# Stratford Extension Project Review Report

April 2014

The Stratford Extension Project is a proposed extension of the existing Stratford open-cut coalmine located 10km south of Gloucester in the Gloucester Local Government Area. Three mining areas are proposed, with approval sought to extract 21.5Mt of ROM coal over 11 years to 2025 at a rate of up to 2.6Mt pa. The coal would be processed on-site using existing facilities and be transported by rail to the Port of Newcastle for shipment overseas. The coal from this project is high quality and is used extensively for blending with coal from the Duralie mine located 20km further to the south. Coal from Duralie is also processed at Stratford.

Figure 1: Project General Arrangement and AGL Wells Surrounded by Offset Area

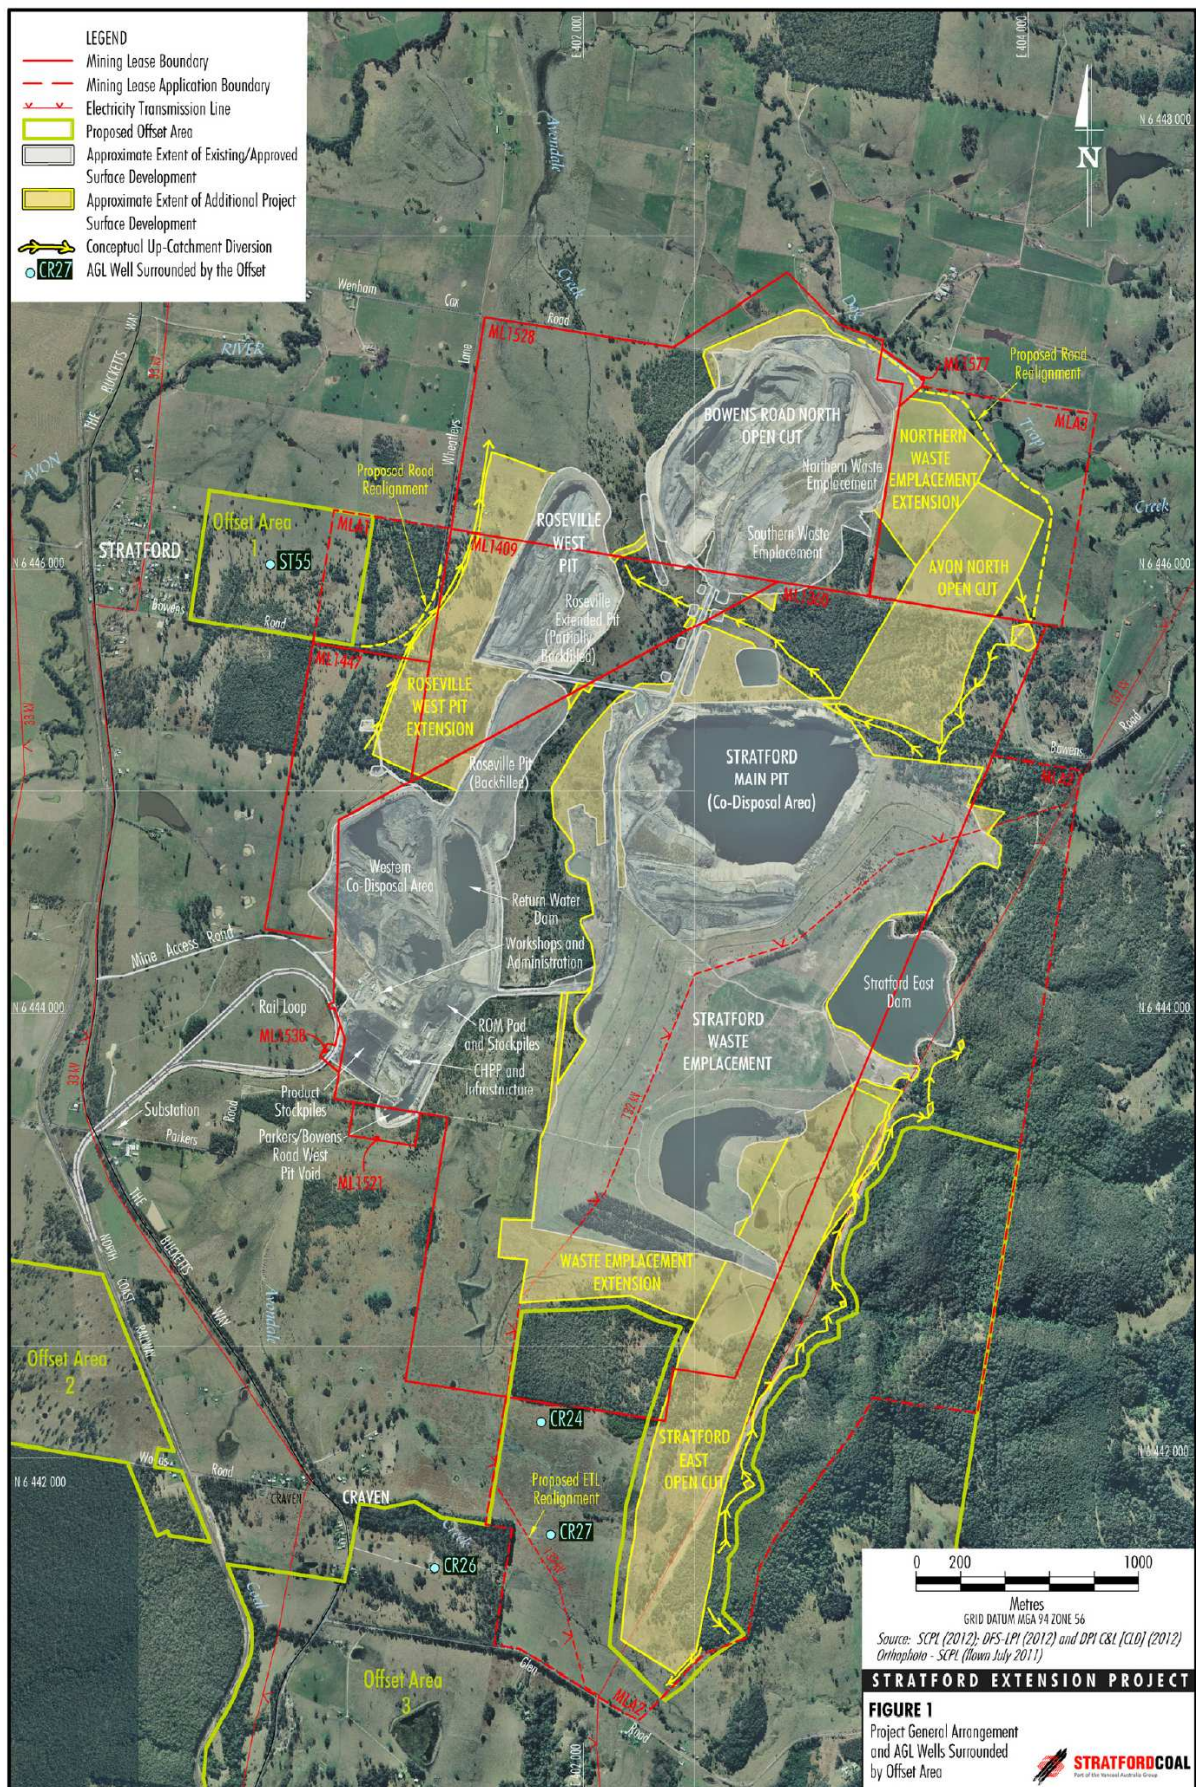
As for the offset strategy proposed for biodiversity impacts that could not be avoided or mitigated, the Commission notes that it is based in part on a false premise concerning the conservation status of a large parcel of land with high conservation value that is situated between two of the proposed offset properties. There is in fact no instrument that would ensure conservation in perpetuity over this land.

The Commission also identified numerous other issues with the suitability of the four properties identified as offsets including the very substantial areas requiring revegetation, infrastructure intrusions (including AGL gas wells, houses and re-located transmission line) and the fact that the Office of Environment and Heritage (OEH) is not prepared to include these properties in their current condition in the conservation agreement program under their control.

The Commission recommends that the offset strategy be revisited in the absence of the voluntary conservation agreement (VCA) over the linking property, that the strategy be expanded to include enhanced protection for Squirrel Gliders, and that a legally robust mechanism for conserving the proposed offset areas in perpetuity be developed prior to determination of the project.
